Development Management
Lincolnshire County Council
County Offices
Newland
Lincoln LN1 1YL
Tel: 01522 782070
developmentmanagement@lincolnshire.gov.uk

Application Ref: H16-0552-26

Proposal: **Erection of a 3-storey care home development with associated car parking, amenity space and ancillary structures**

Location: **Land off Shakespeare Way, Holland Park, Spalding**

Site Plan
1 : 500

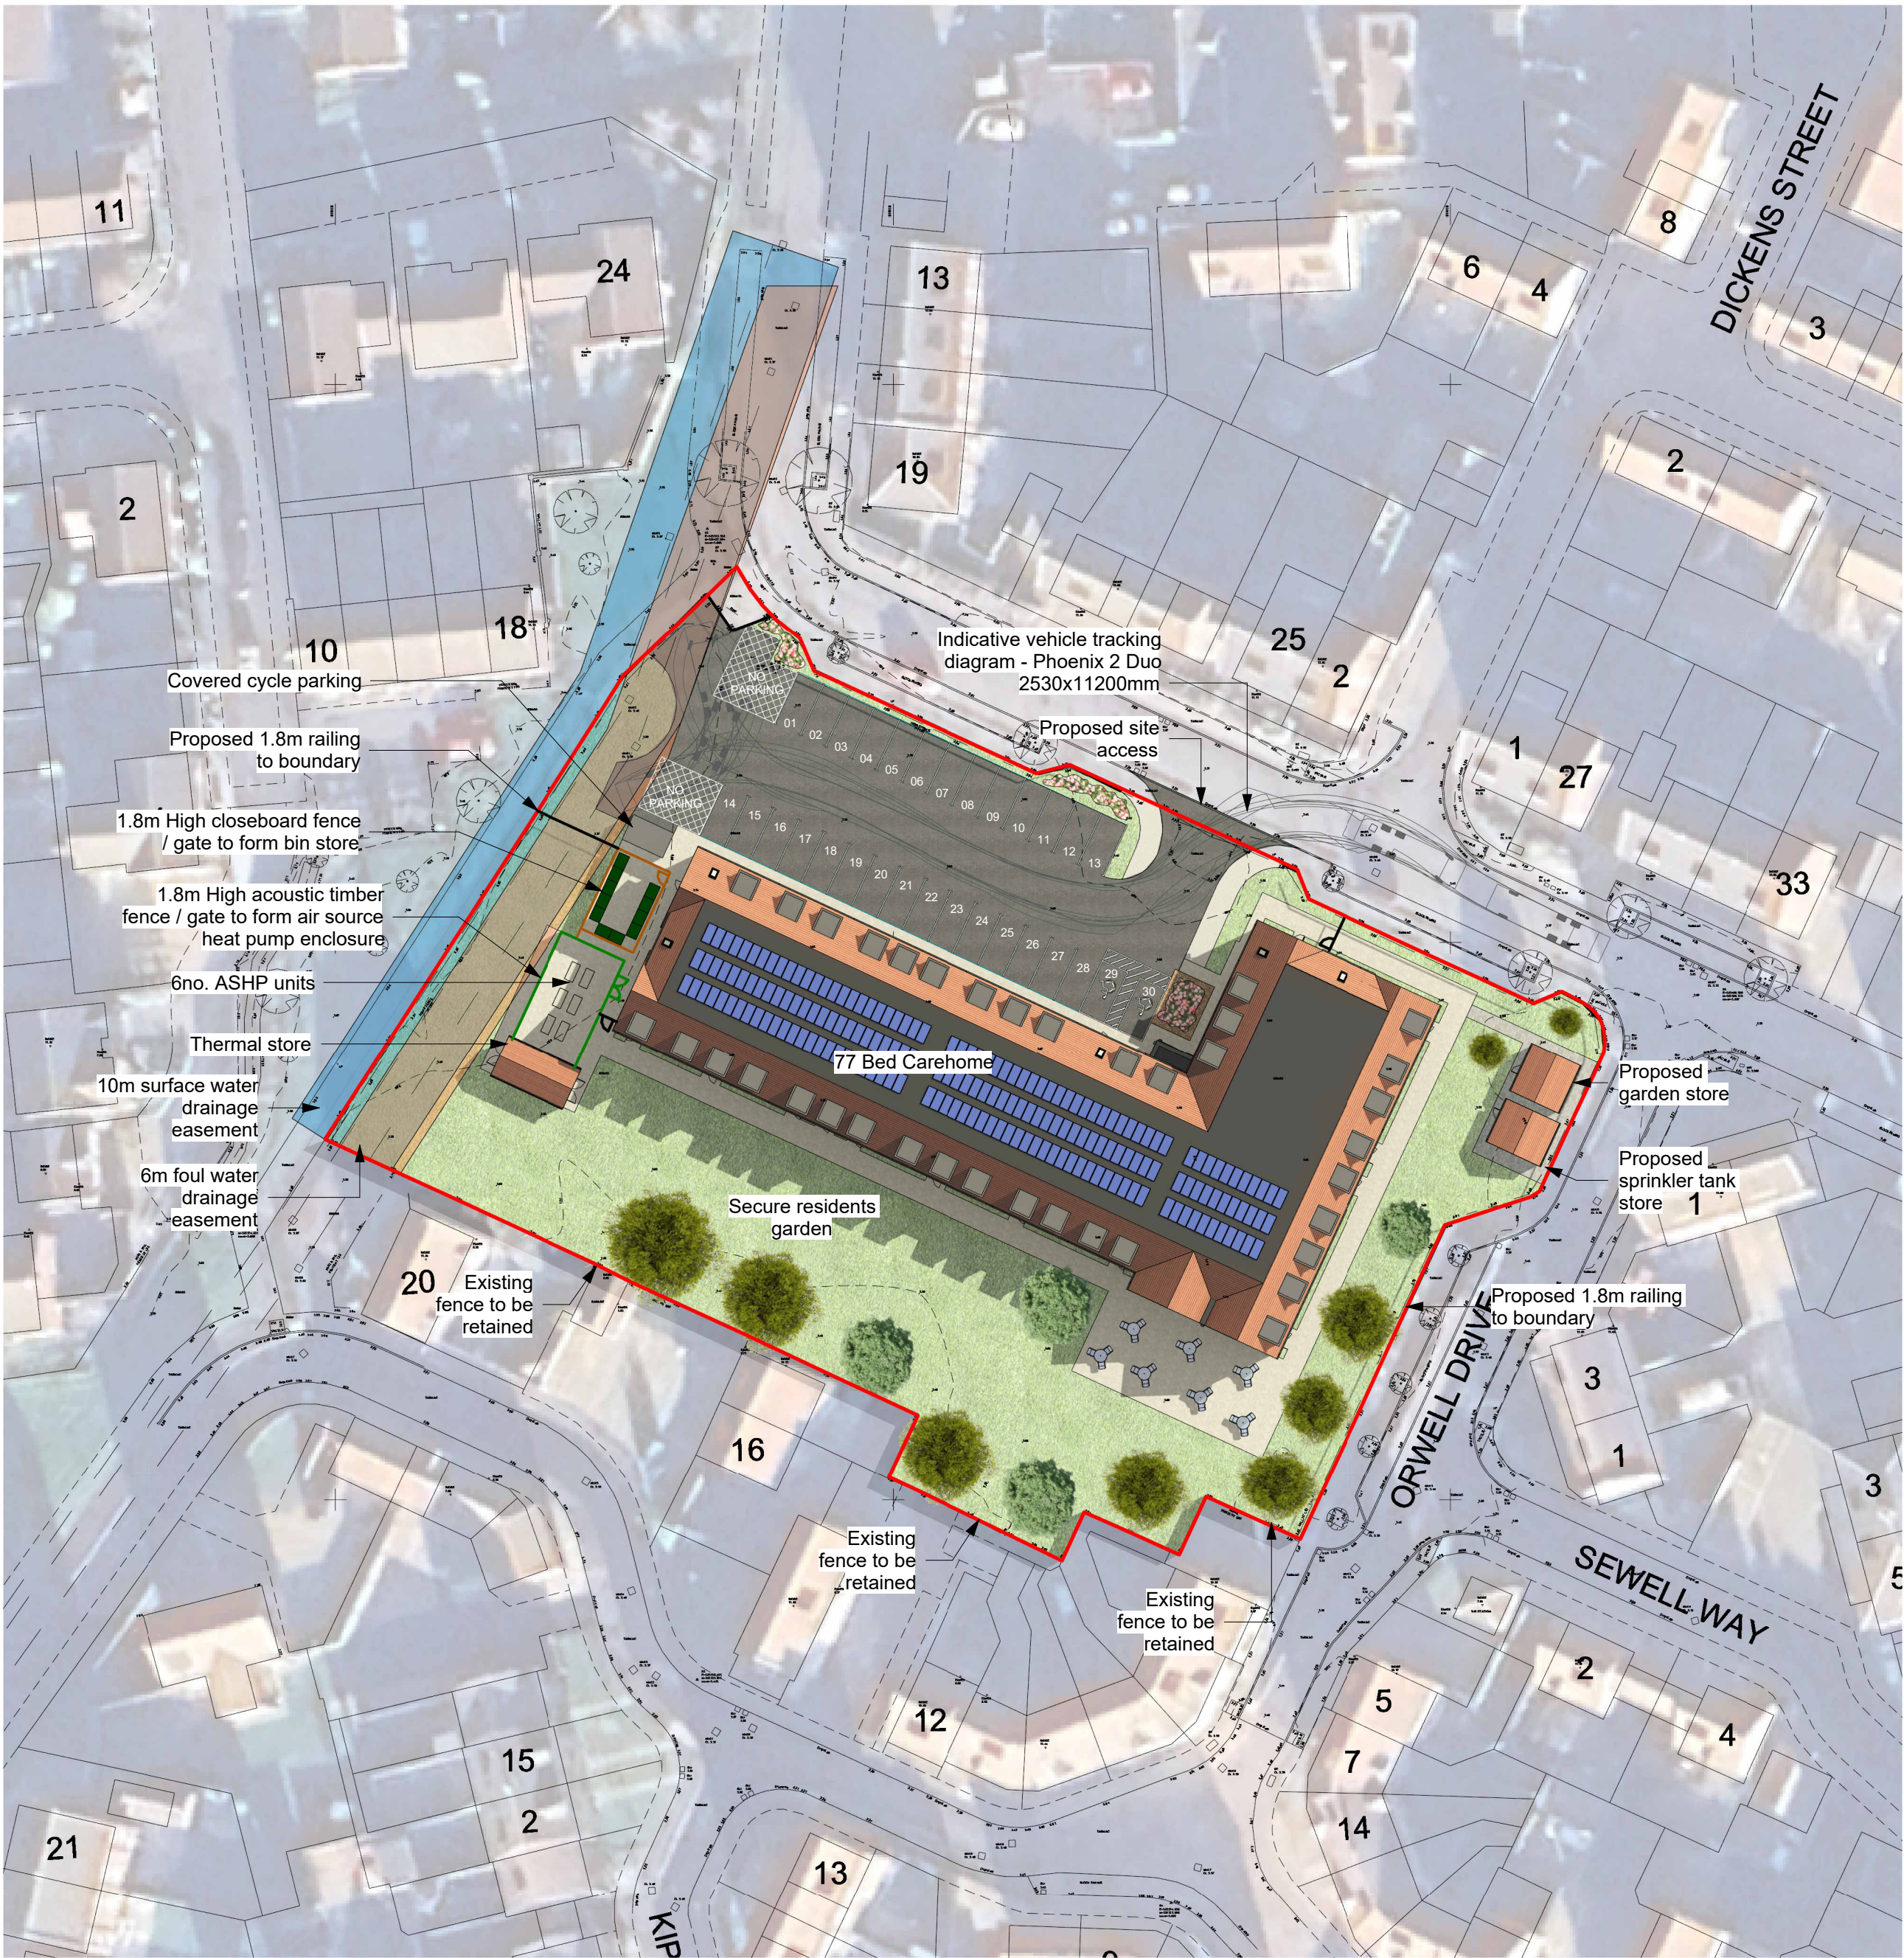
The proposed site access has been designed to accommodate large vehicles, with a 6.0m carriageway width and relatively generous corner radii. While this demonstrates technical compliance in terms of vehicle tracking, the geometry appears excessive in the context of the anticipated traffic levels and the nature of the development. This results in unnecessarily wide crossing distances and is likely to encourage higher vehicle speeds at the point of access, to the detriment of pedestrian safety.

There is a clear opportunity to refine the access design to better align with placemaking principles by reducing carriageway width and tightening kerb radii, thereby prioritising pedestrian movement and improving the overall quality of the frontage. The use of overrun

areas or reinforced margins (e.g. crossing pavers) could be considered to accommodate occasional larger vehicles without compromising the day-to-day function of the access, as well as block-paving across the access to highlight pedestrian priority when crossing. Please see the wider site where materials have been used to prioritise pedestrians.

Cycle parking provision is acceptable in terms of quantity; however, its proposed location appears poorly integrated within the site layout and does not reflect best practice guidance. It should be repositioned closer to the main entrance, where it benefits from natural surveillance, lighting, and a clear, direct route that avoids conflict with vehicular movements.

- Review the proposed access geometry to reduce carriageway width and kerb radii to better prioritise pedestrian movement and minimise vehicle speeds, whilst still accommodating occasional service vehicles.

- Relocate cycle parking to a more prominent, convenient and overlooked location close to the main entrance, ensuring safe and direct access without conflict with vehicles.
